From: Susan Leeson
Sent: 10 April 2012 12:48
To: Planning.Responses
Subject: FW: P/92/11/DOC (Discharge of Conditions)
Attachments: NE Barn_Owls_On_Site_booklet_PDF[1].pdf

ADC ref: P/92/11/DOC

**Butterlees Barn, Butterlees Farm, LAGNESS
 Application P/145/08 – Discharge of Conditions**

BUTTERLEES BARN - LAGNESS
BARN & BYRE ELEVATIONS AS PROPOSED
LWG/BUT/D.OGE 1:100 C.A.B. JU 008
MALCOLM SIMMONDS ARCHITECTS

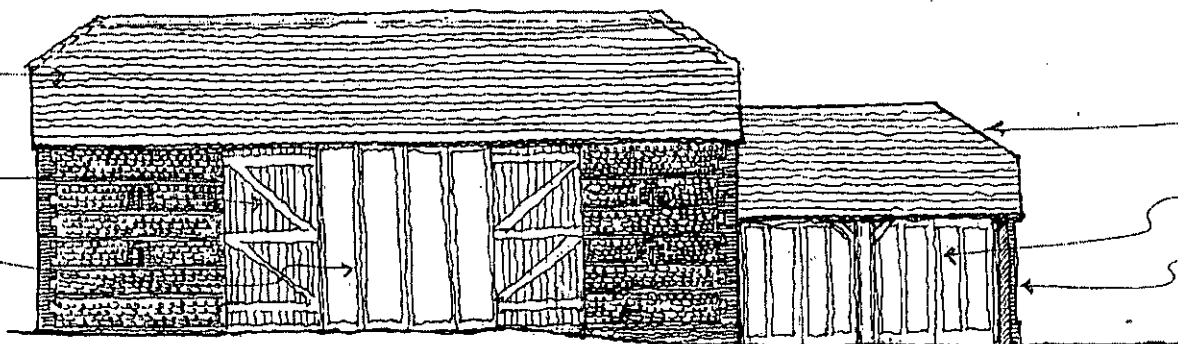
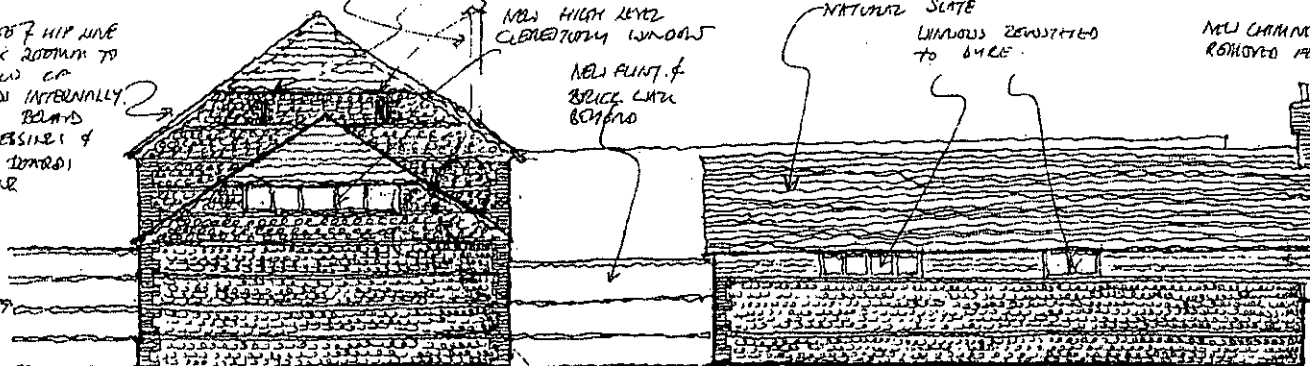
Thanks for the additional information. The locations for the bat boxes and the owl box seem appropriate. One would normally expect greater detail in terms of the design of the owl loft rather than simply a proposal to install an owl box in the roof void. Figs. 2 & 3 in attached Natural England guidance show how an owl loft can be created. If the applicant can commit to a similar design, I would then discharge the condition.

In summary, two bat boxes have been provided on the preferred south west elevation, these would be Habitat Bat Boxes with a custom brick facing to match the existing building. the owl box would be located on the south west corner of the building facing open fields and built into the building to provide the sort of shelter that Owl's prefer as well as be a discreet addition to the building.

BUTTERLEES BARN - LICHNESS
 BARN & HOVEL ELEVATIONS AS PROPOSED
 DWG: BUT/D.07E 1:100 CAS JUL 2008
 MALCOLM SIMMONDS ARCHITECTS

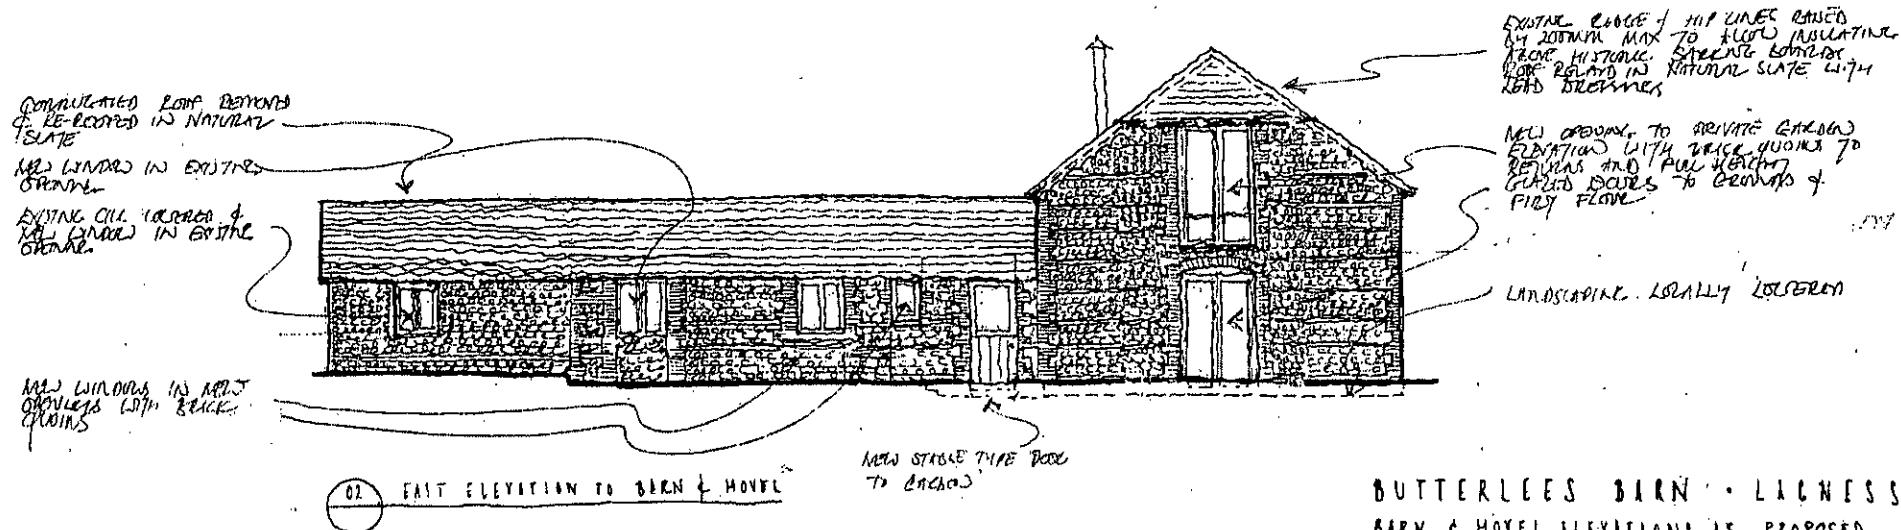
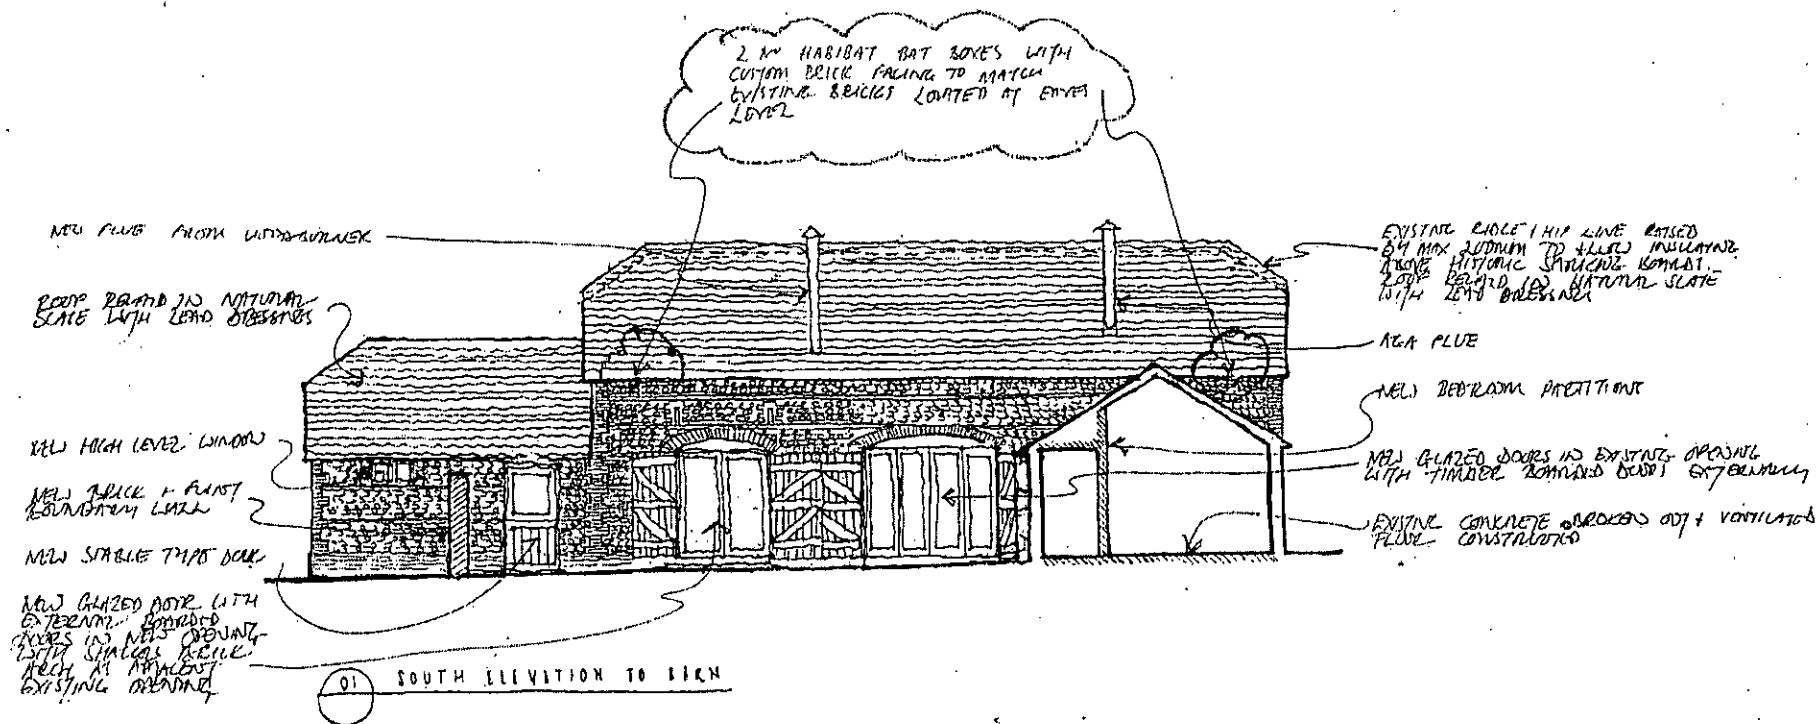
I note that Don, in his comments of 6th Feb 2012, recommended access and nesting provision (e.g. Schwegler No. 10 nestbox) should be provided for Swallows. Maybe this wasn't conditioned.
